Examination Library Reference	Chapter and Title,	Summary of Changes/Issue, Paragraph/Table Reference	BCKLWN comments
REP3-030	Chapter 10: Noise and Vibration	10.1.6 This document has been updated at Deadline 3 to update the cumulative assessment to reflect the updated list of cumulative schemes (ES Appendix 2.4: Cumulative Schemes [App/6.4.1].	The addition of 1B in Table 10.7 regarding Jafa Solar Farm is welcomed, likewise the inclusion of 10.11.10, 10.11.14, 10.11.15, 10.11.16 and 10.11.25, plus the inserted text in relation to Jafa Solar Farm in 10.11.18 and 10.11.19. The Council has no further comments in regard to Noise or Vibration impacts.
REP3-067	Outline Decommissioning Strategy	The document has been updated at Deadline 3 to include additional measures related to dust monitoring and cumulative effects.	The Council note the revisions in regard to dust sensitive receptors and their grid positions being agreed with local authorities as part of the detailed CEMP. This is welcomed. The Council has no further comments at this stage.

BCKLWN responses to Deadline 3 Submissions
PIN Reference No. EN0110013 – The Drovers Solar Farm

Figure 2-1 Site Access Overview

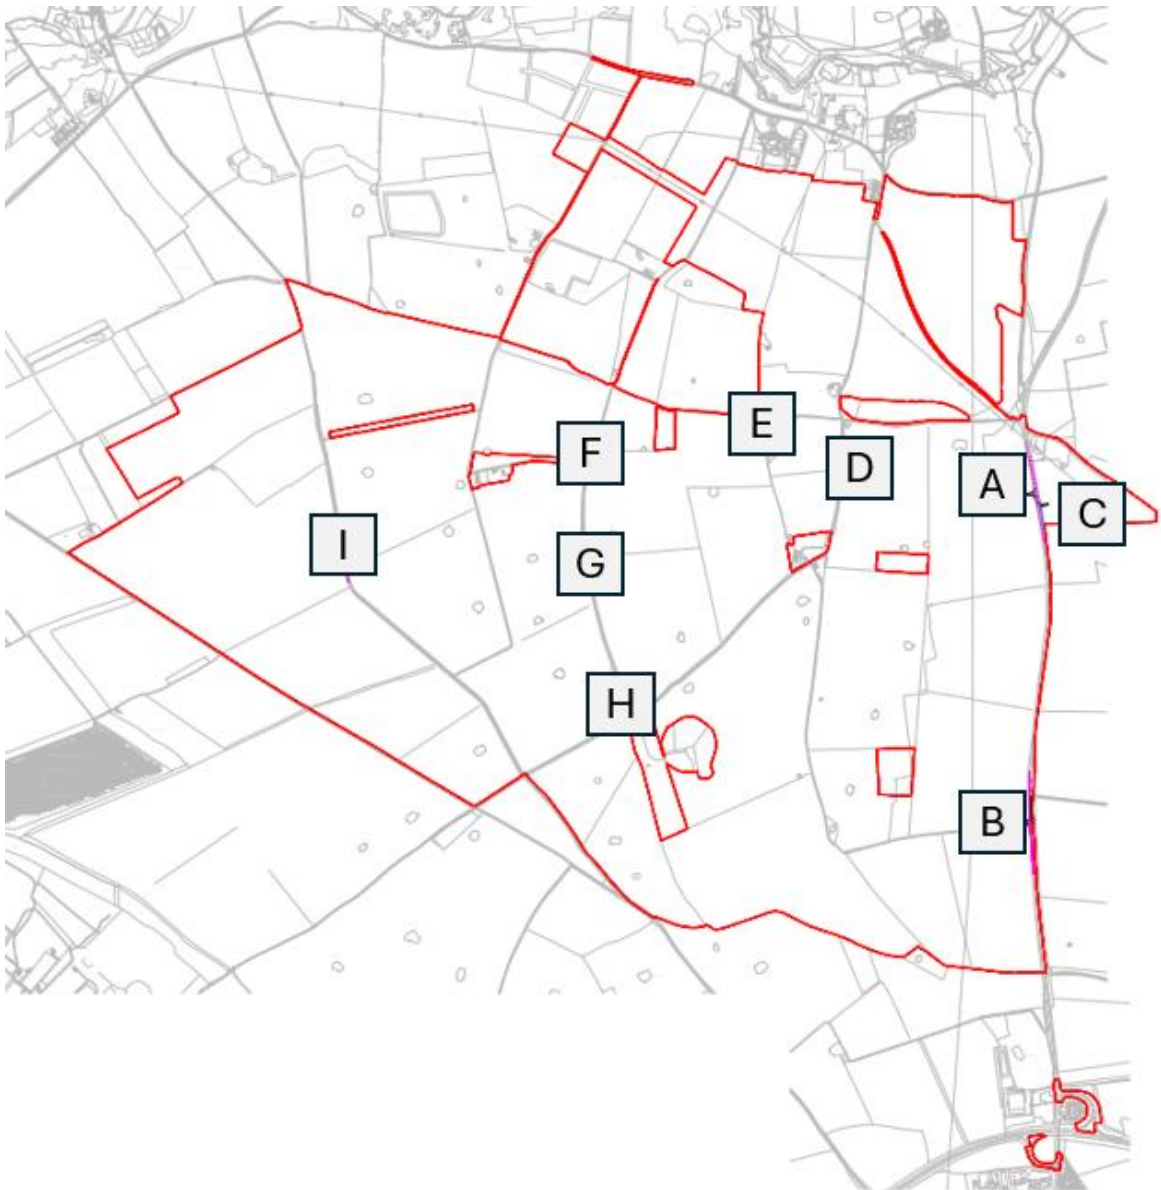
REP3-075	outline Construction Traffic Management Plan	The document has been updated at Deadline 3 to provide clarity on construction vehicle routing.	2.3.3 confirms proposed access points for the scheme. As these three access/egress points are all directly off the A1065 between South Acre and Swaffham (confirmed in Table 2-1 'Access Strategy Overview'), construction HGVs etc will not impact on residential receptors in this Borough. The revision of 3.1.6 in regard to a daily cap of 96 two-way HGVs and 532 two-way cars / LGVs during the construction phase of the Scheme is also positive.

Figure 4-1 Proposed Construction Routing Overview

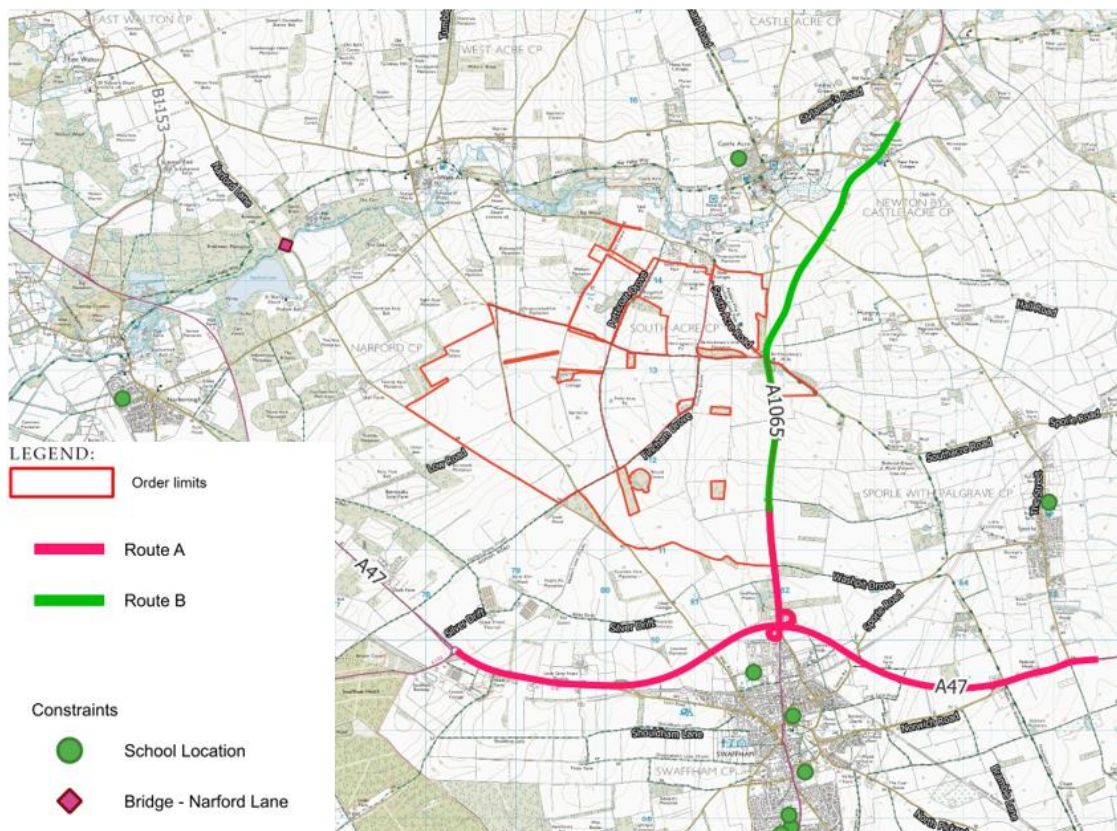
Figure 4-1 now confirms that only routes A and B will be used for construction routing. Removal of route C for construction vehicle access and egress is welcomed, keeping the significant vehicle movements to the main routes rather than side roads/rural roads where noise impacts would be heightened. The Council welcomes the revisions to 8.2.1, 8.2.2, 8.2.12 and 8.2.13, along with 8.3.1 and 8.3.2, plus 8.5.3, 8.5.4, 8.5.5 and 8.5.6. Although these are mainly related to Highways aspects within the remit of National Highways or Norfolk County Council, construction traffic could have noise impacts on residential amenity, so the monitoring of vehicle movements and recording of such would be beneficial if complaints are received from residents.
REP3-079	outline Operational Traffic Management Plan	1.1.3 advises this document has also been updated at Deadline 3 to provide clarity on construction vehicle routing	Please refer to the Council's response to the oCTMP above. No further comments at this time.
